TransGrid Reference Number: 2020-434

Location: 106-228 Aldington Road Kemps Creek LOTS 30-32 DP 258949
& LOTS 20-23 DP 25560

Proposal: Industrial Estate consisting of 13 warehouses

TransGrid: Transmission Line 14 Sydney North 330kV – Kemps Creek
500kV Structure: 110-111 + Potential Future Network Easement

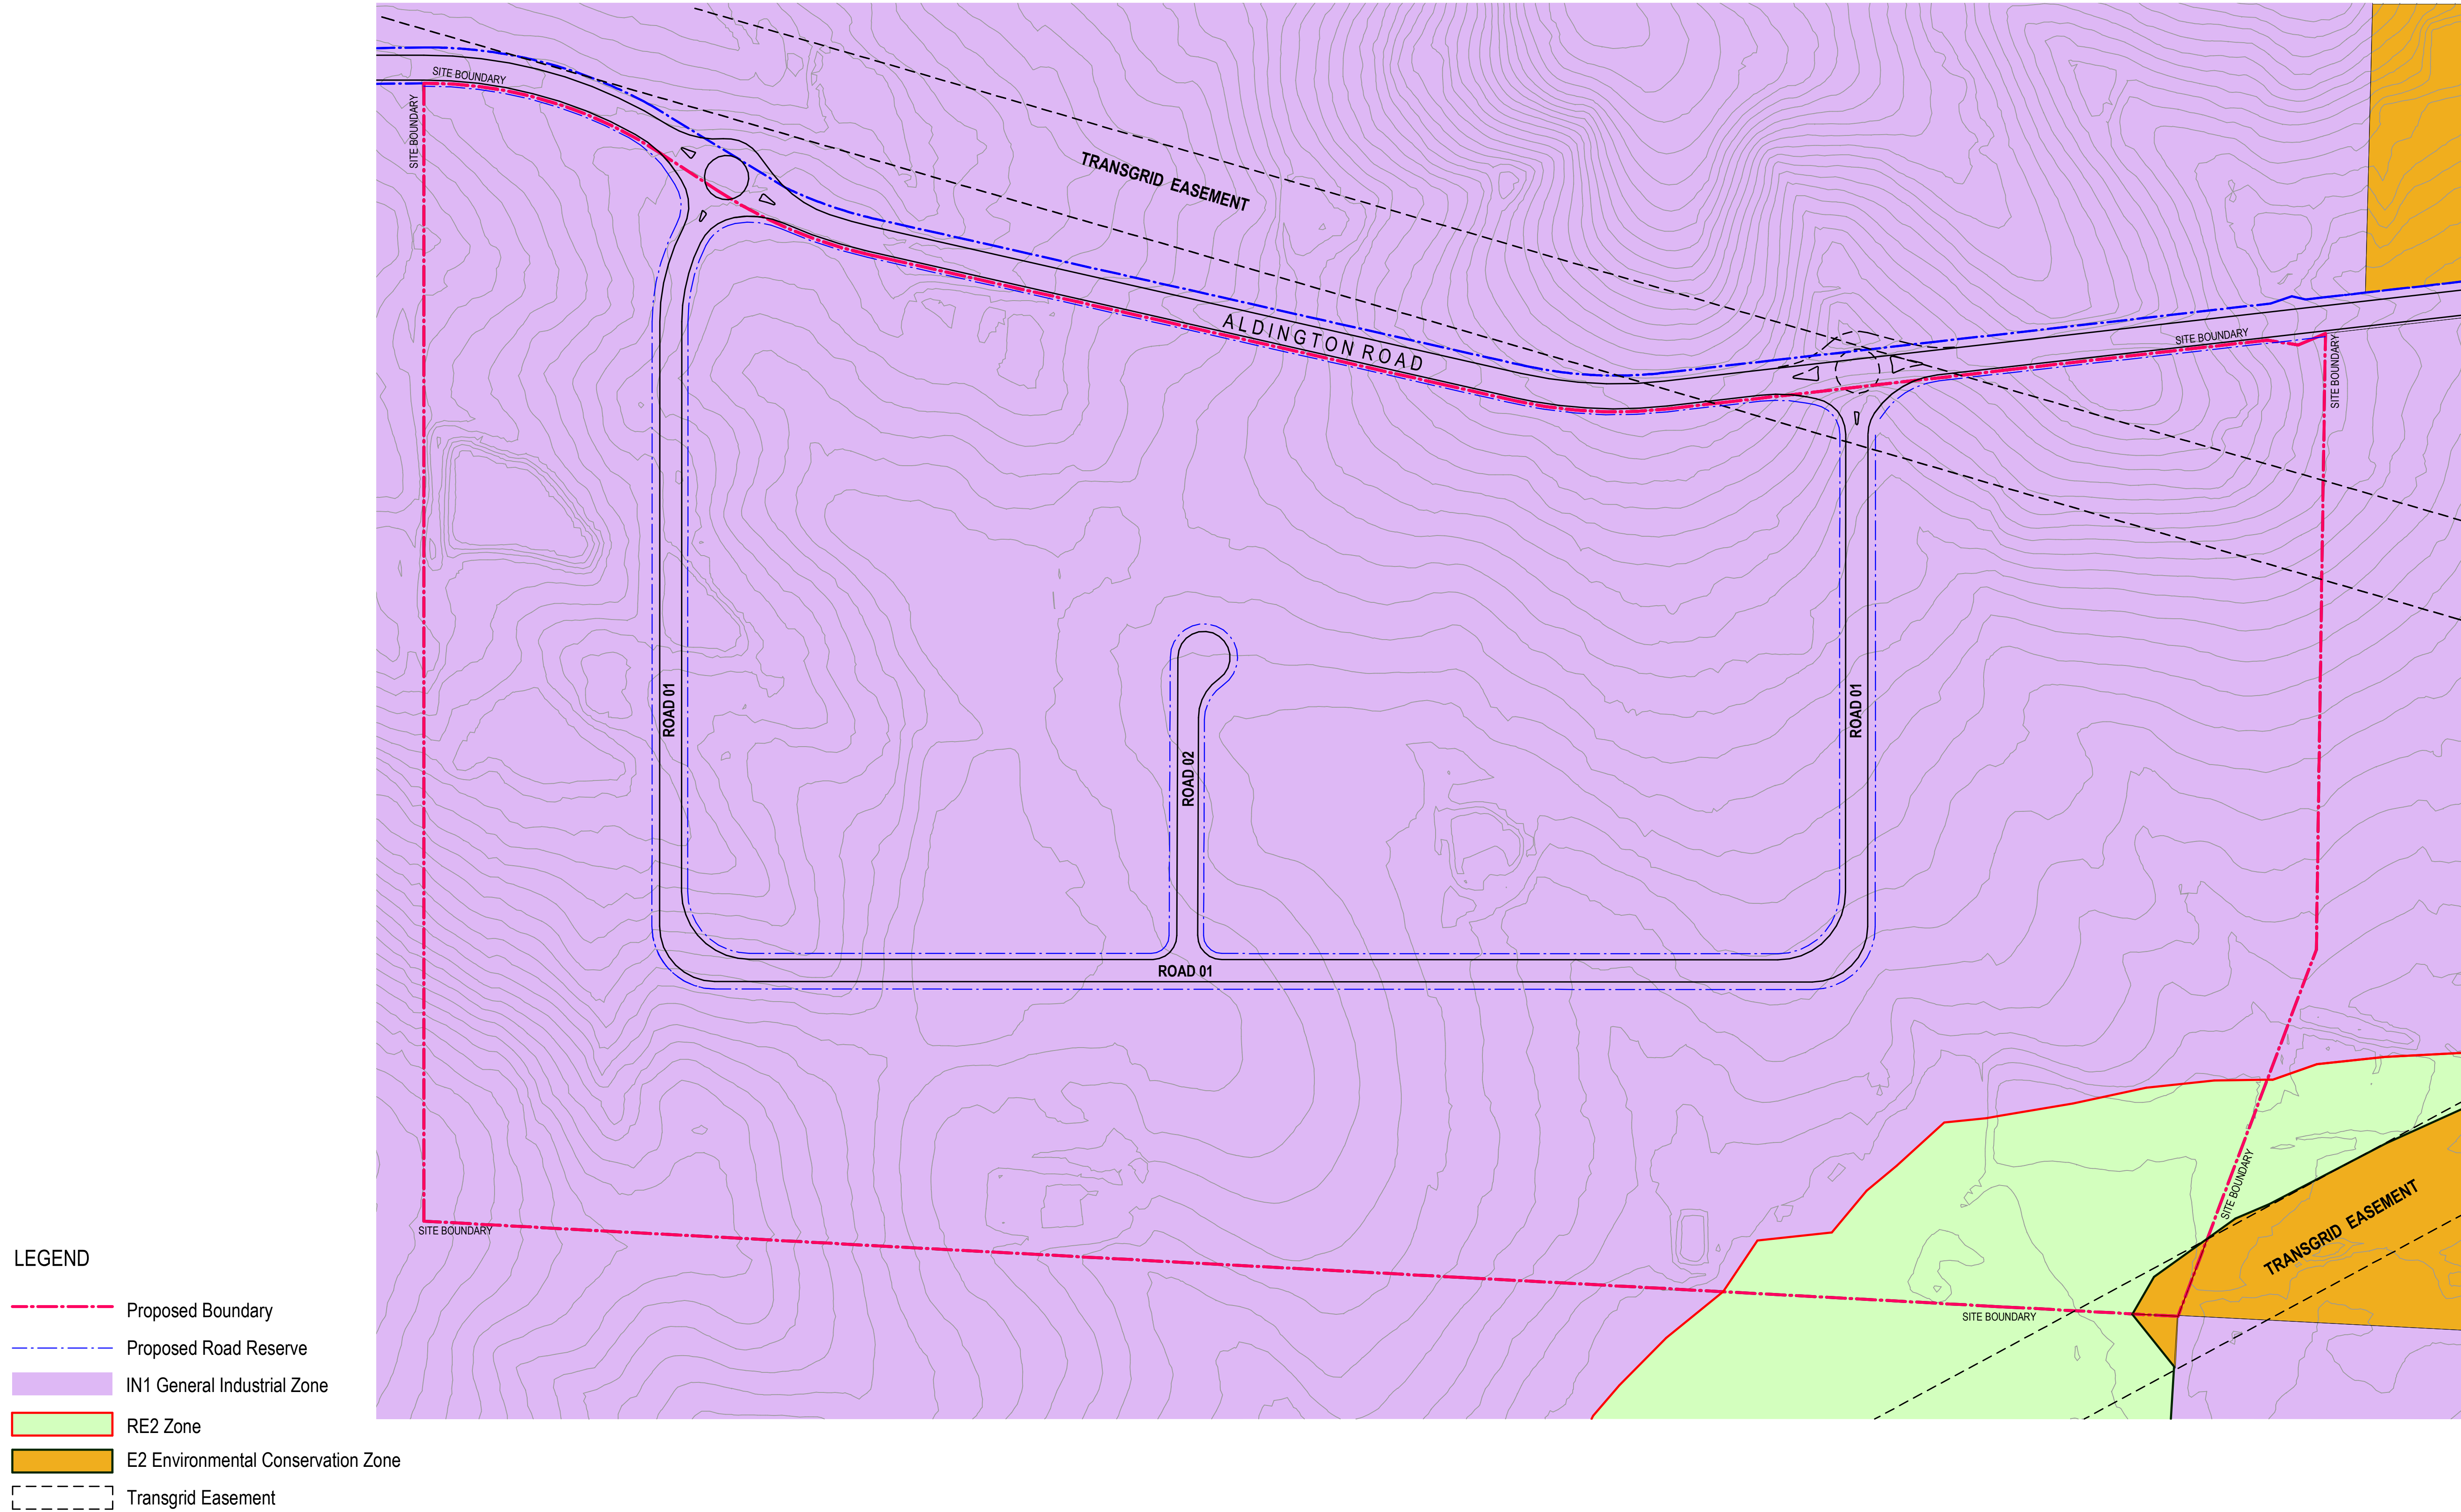
- A. A three-way roundabout intersection is proposed across the width of the **Potential Future Network easement** which places a junction on the centreline. Refer figure 3. This is not in accordance with TransGrid's Easement Guidelines. Any such proposal must meet Roads and Pathways 1.e) that cross the easement below
- B. Metallic "pylon" type of signage is proposed within 17m of the easement centreline. Refer figure 2. This is not in accordance with TransGrid's Easement Guidelines and 1.a) Metallic Structures (signage) below would apply
- C. Metallic "pylon" type of signage of 3.3m in height, is proposed within the easement. Refer figure 2. This is not in accordance with TransGrid's Easement Guidelines. and 1.a) Metallic Structures (signage) below would apply

In order to be acceptable, the following conditions would need to be adhered to, including A, B and C above and plans showing how TransGrid's Easement Guidelines have been met submitted to TransGrid for review.

e) Roads and pathways that cross the easement:

- i. At least 20 metres from any part of a transmission line structure
- ii. Where a road passes within 30 metres of a transmission structure or supporting guy, the structure's earthing system may require modification for reasons including, but not limited to, preventing fault currents from entering utility services or metallic barriers which may be on the road
- iii. Intersections within the easement must be at least 10 metres from the transmission line centre line 132kV or below or at least 17 metres from the transmission line centre line above 132kV
